Recommendation Report for Lawful Development Certificate for a Proposed Use or Development

REF NO: AB/25/21/CLP

LOCATION: 48 Torton Hill Road
Arundel
BN18 9HH

PROPOSAL: Lawful development certificate for a proposed loft conversion with rear hip-to-gable enlargement of 20.5 cub.m, with side-facing rooflights with a cill height of 1.7m from internal finished floor level, and rear-facing Juliet balcony.

PROPOSED REAR ELEVATION 1:100

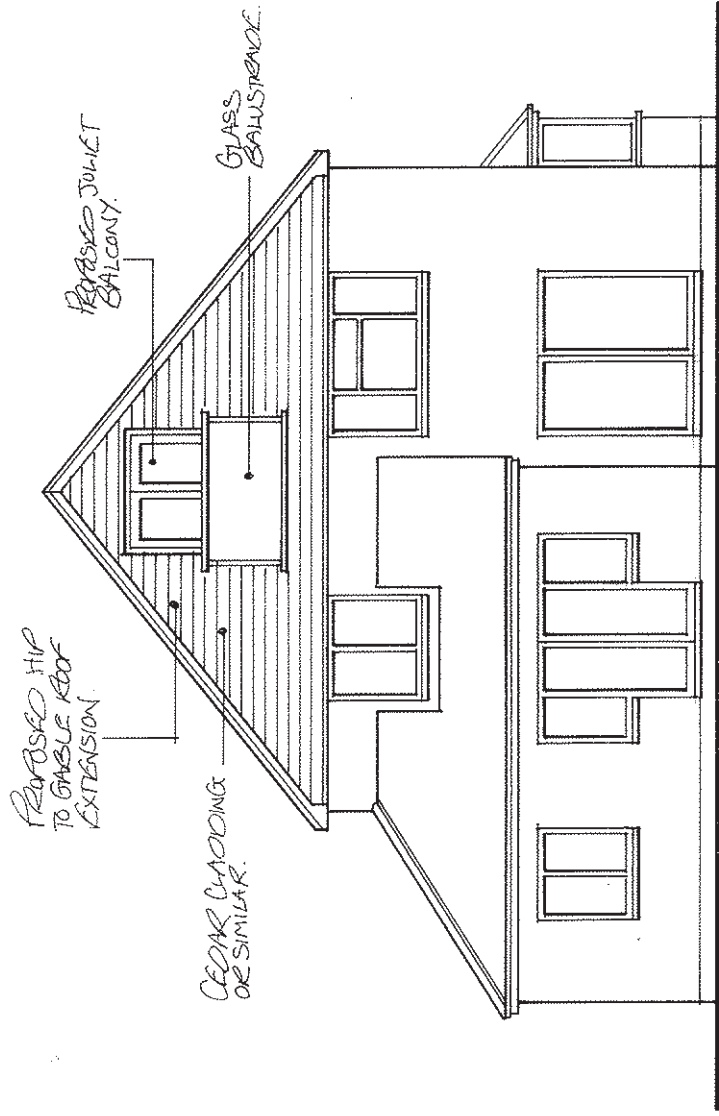
This part is not breached. The Juliet balcony does not have any part which is outside and is therefore considered permitted development.

PROPOSED SIDE ELEVATION 1:100

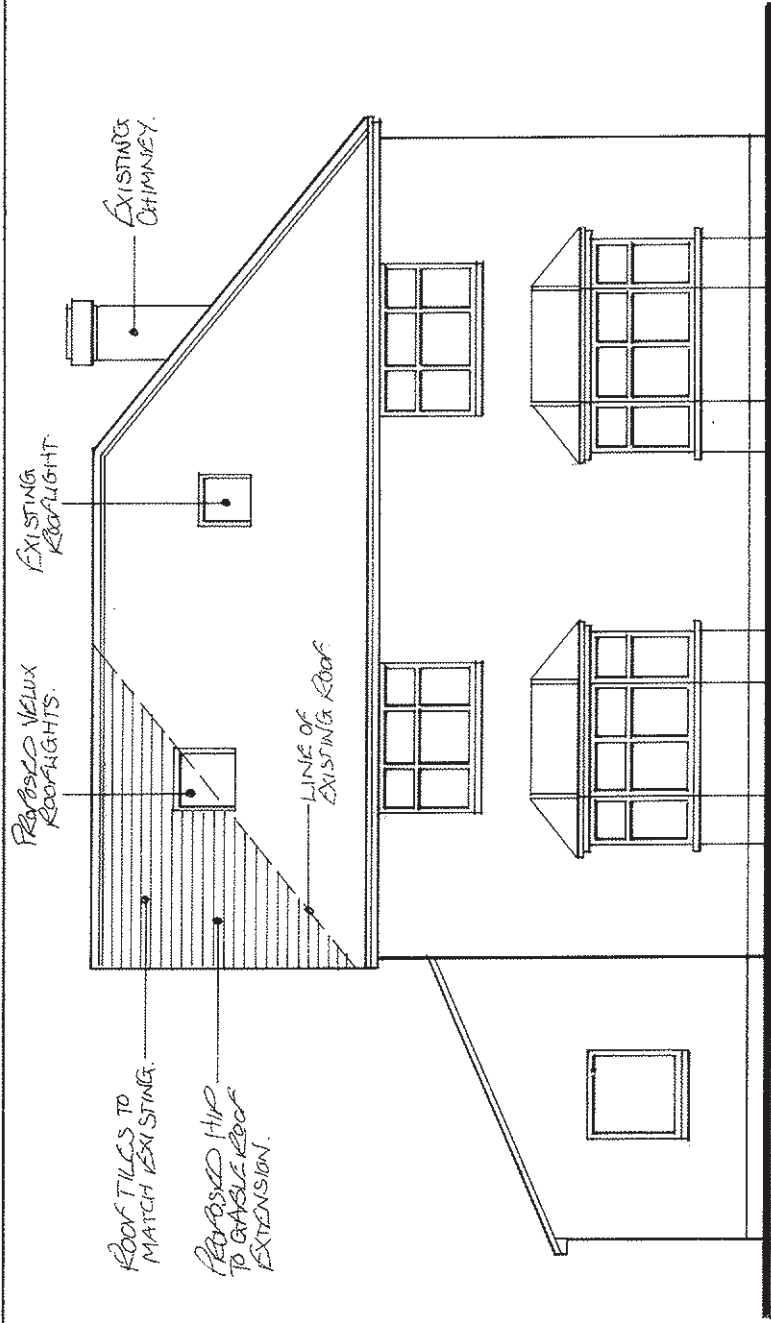
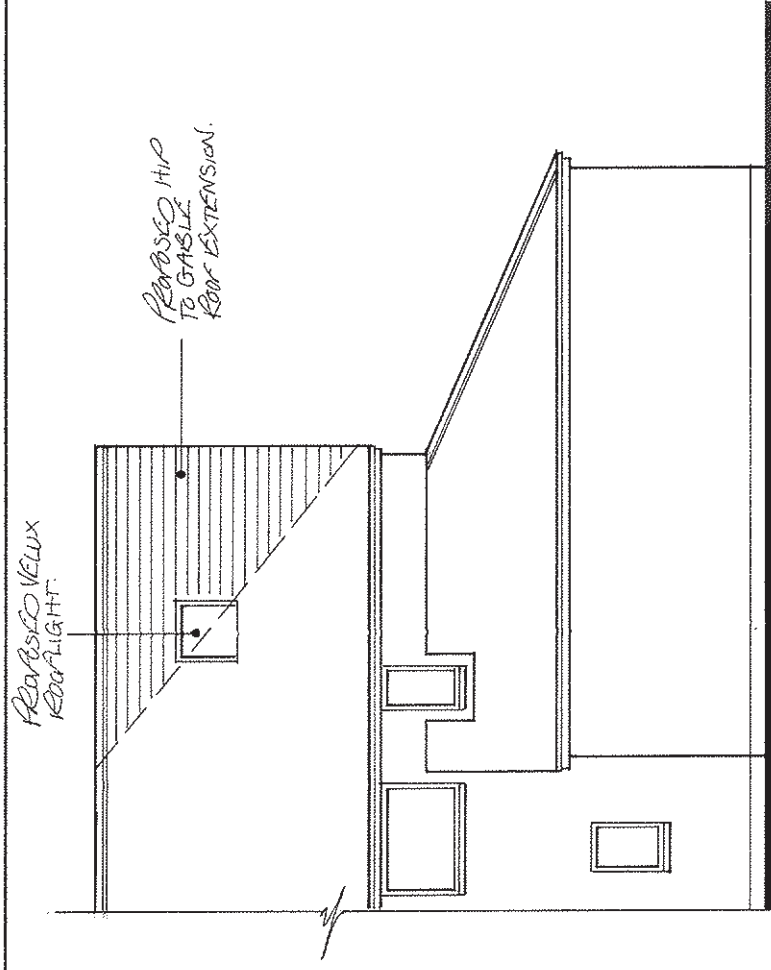
(c) any window inserted on a wall or roof slope forming a side elevation of the dwellinghouse must be-
(i) obscure-glazed, and
(ii) non-opening unless the parts of the window which can be opened are more than 1.7 metres above the floor of the room in which the window is installed.

This is concurred with.

DRAWING TITLE
Existing & Proposed Roof Plans
PLANNING ISSUE

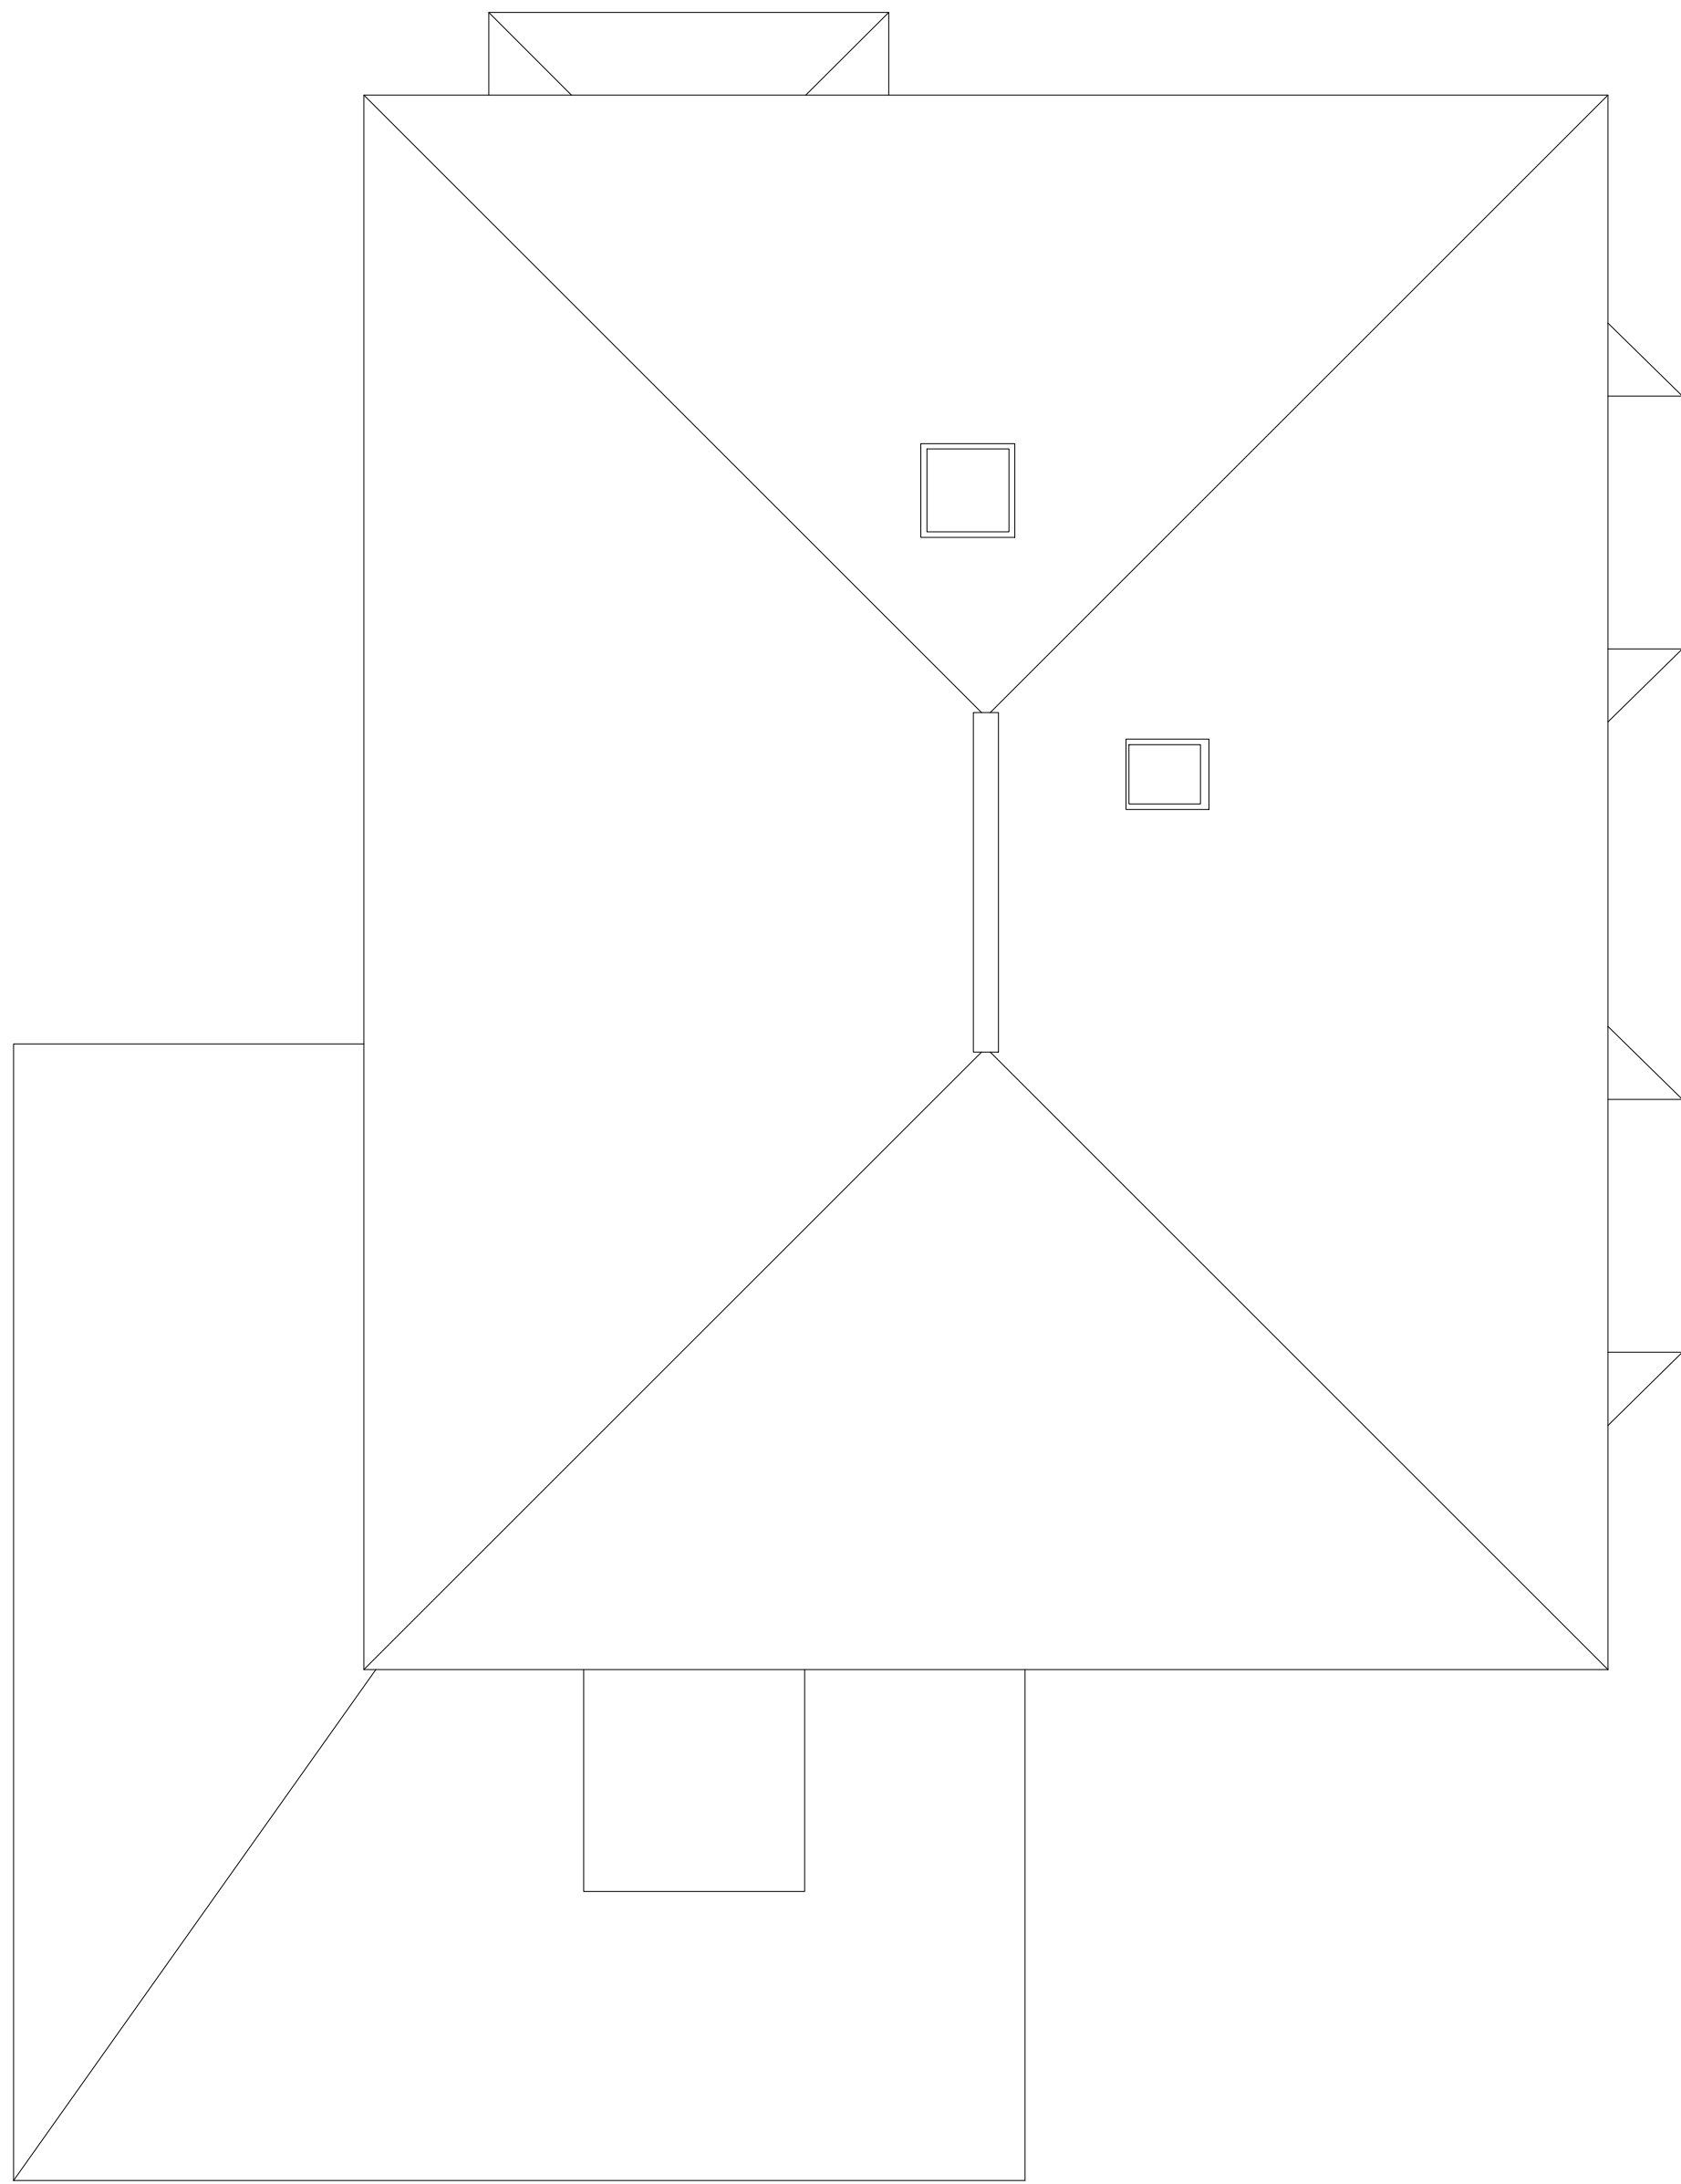
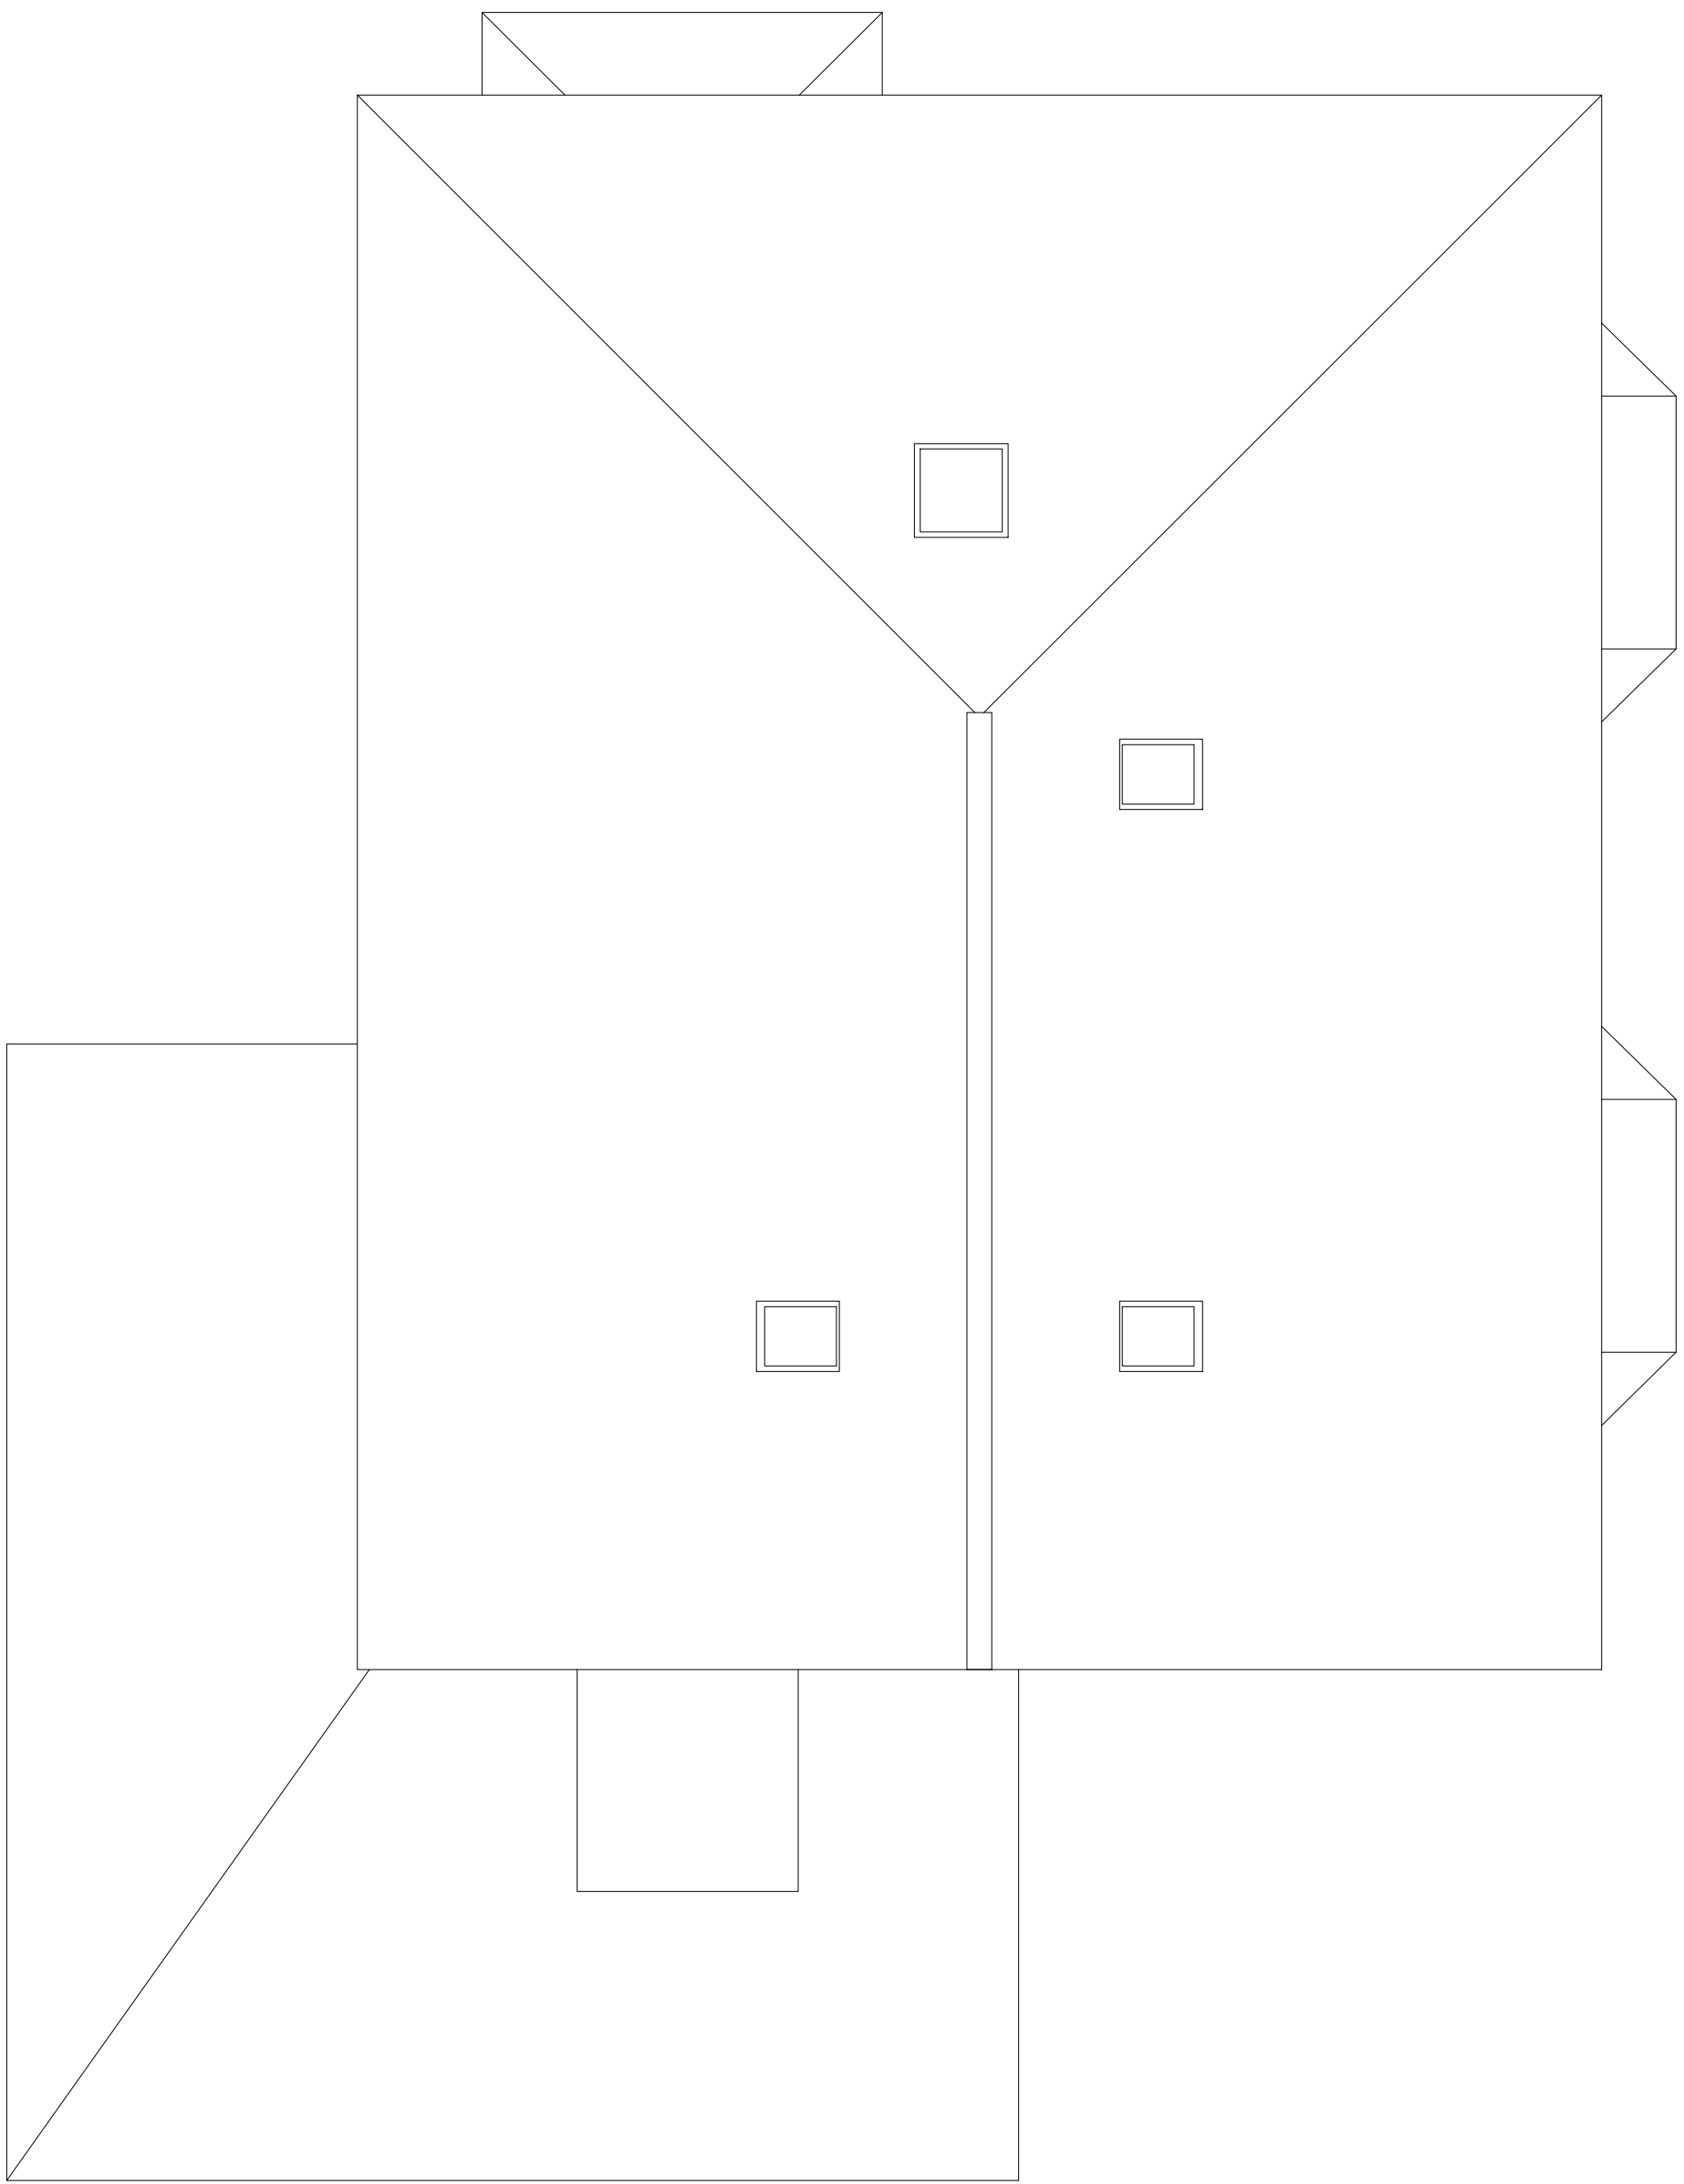
(b) any part of the dwellinghouse would, as a result of the works, exceed the height of the highest part of the existing roof;

The highest part of the roof is not exceeded.

The cubic content proposed is 20.5 cubic metres.
